**From:** Victor Grayson  
**Sent:** 08 August 2025 10:21  
**To:** DC Admin  
**Subject:** FW: 2025/62/91542/E Highmoor Lane, Cleckheaton

**From:** Cllr Kath Pinnock <Kath.Pinnock@kirklees.gov.uk>  
**Sent:** 07 August 2025 10:02  
**To:** Victor Grayson <Victor.Grayson@kirklees.gov.uk>  
**Cc:** Cllr Andrew Pinnock <Andrew.Pinnock@kirklees.gov.uk>; Cllr John Lawson <John.Lawson@kirklees.gov.uk>  
**Subject:** 2025/62/91542/E Highmoor Lane, Cleckheaton

The application for 40 units with some for social rent helps to fill a need in the locality. However, I am concerned that, despite the plans showing a potential access onto Halifax Road, that a decision has been made to restrict access for these 40 houses to Highmoor Lane. What consideration has been given to using both accesses? The traffic lights at the Halifax Road / Moorside / Highmoor Lane are 3 way so that vehicles coming out of Highmoor Lane do so when all other roads are on a red. Of course, as a minor road the phasing means that the greater time is given to the main Halifax Road. With 40 houses that will considerably increase the use of that phase and seems likely to mean that there will be waits for 2 phases or perhaps m

DRAWING TITLE
Proposed Site Layout

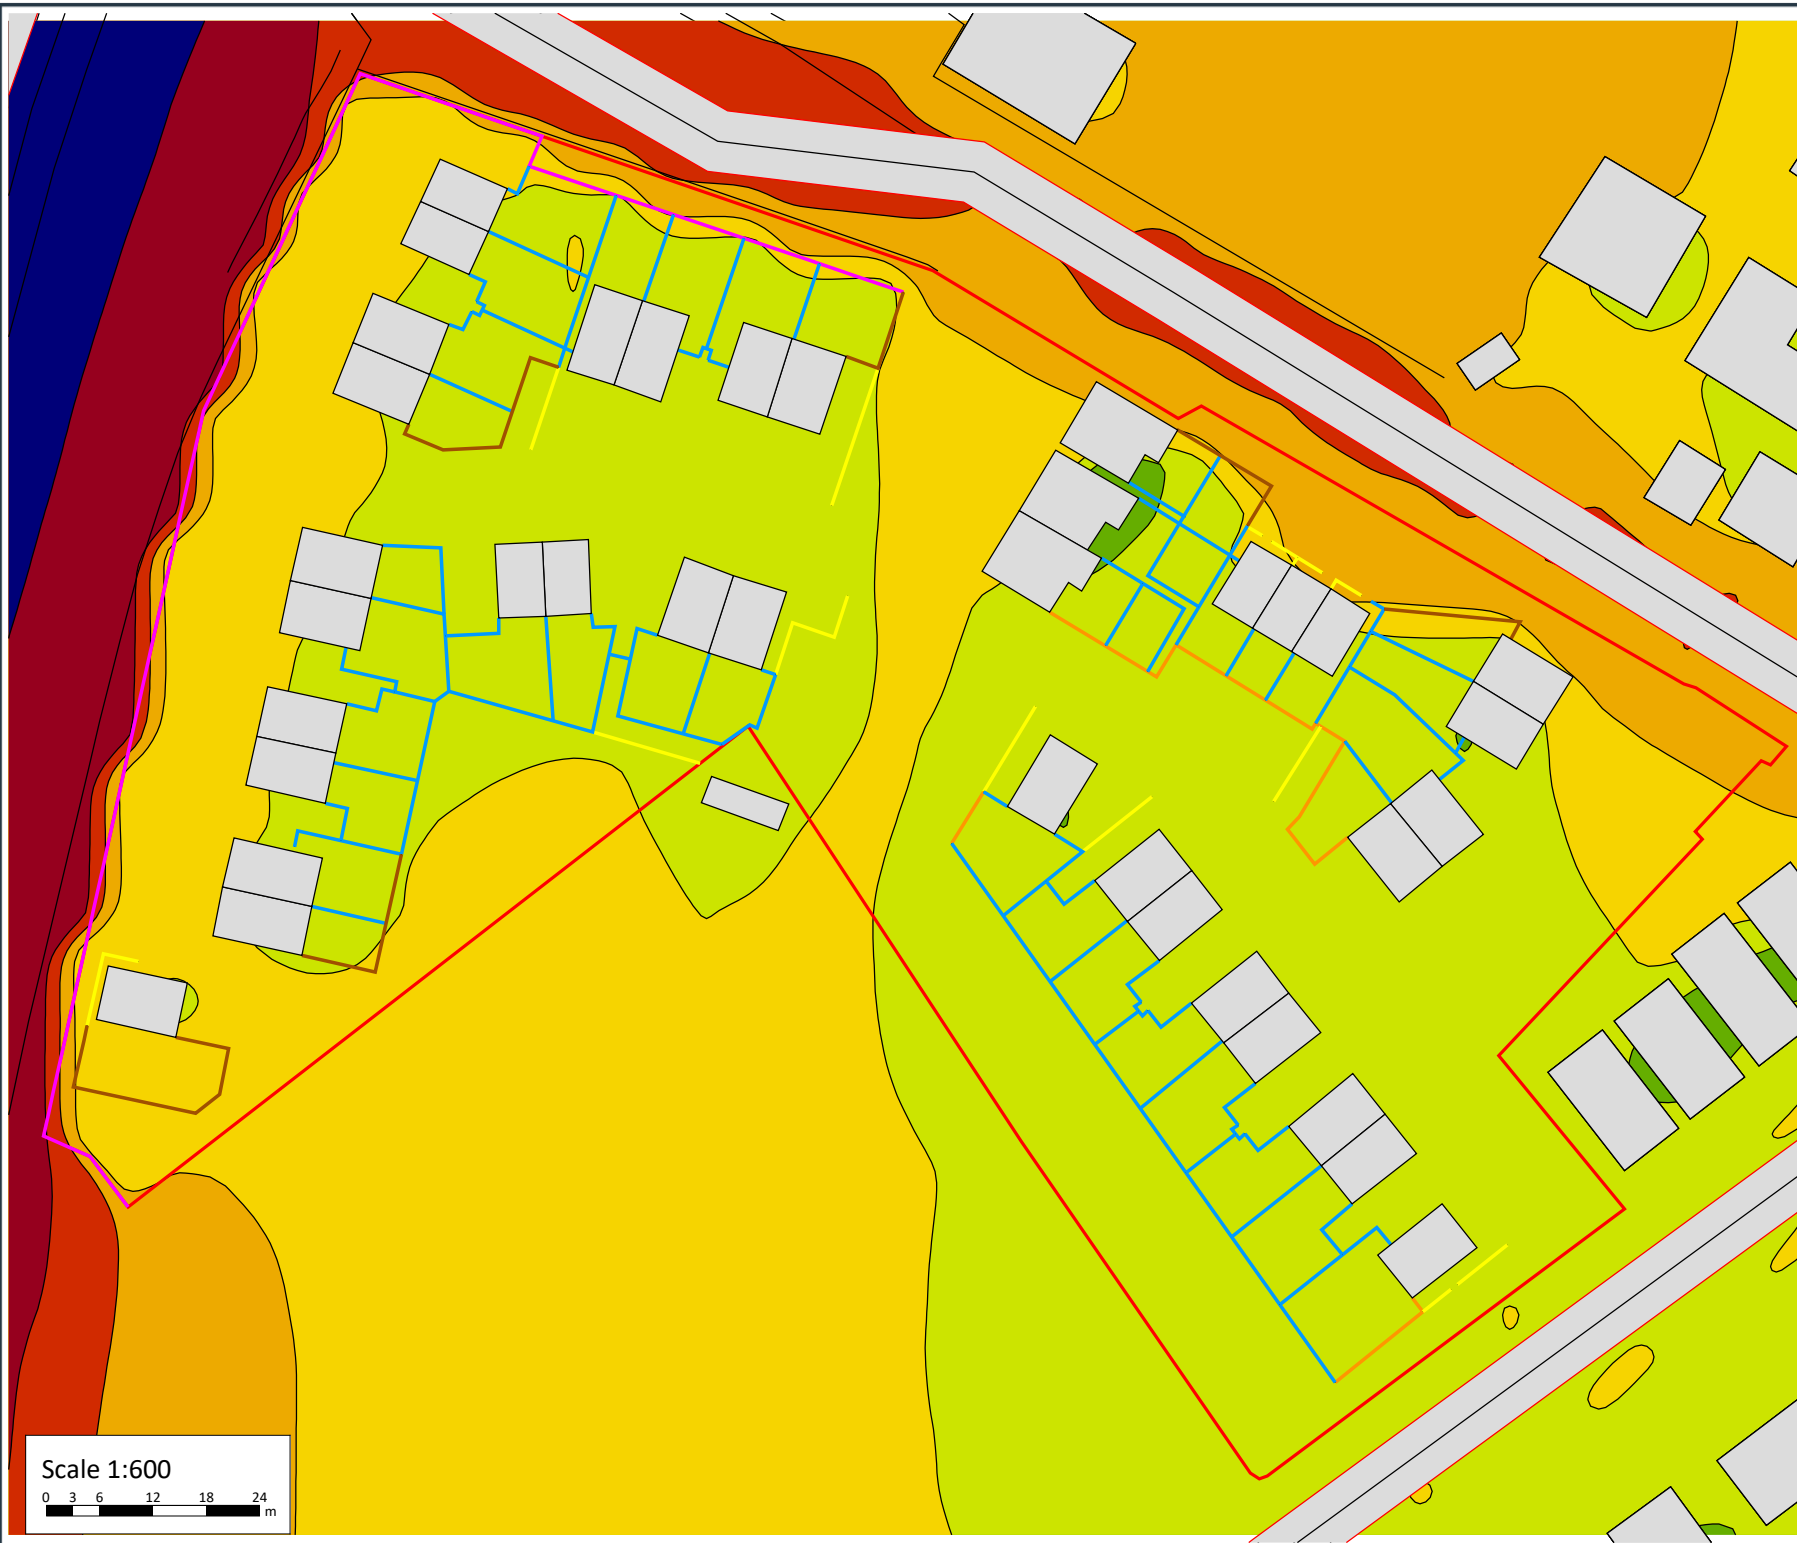
What are the reasons for not permitting an access onto Halifax Road?

Has any thought been given to provide an access onto Halifax Road that is a left turn only?

I accept that one of the disadvantages of doing that is that it may become a shortcut to avoid the lights. That could be addressed by ensuring that speed reduction measures are part of the plan. As the Streetscene plan wouldn't open, I have not been able to check what measures are planned.
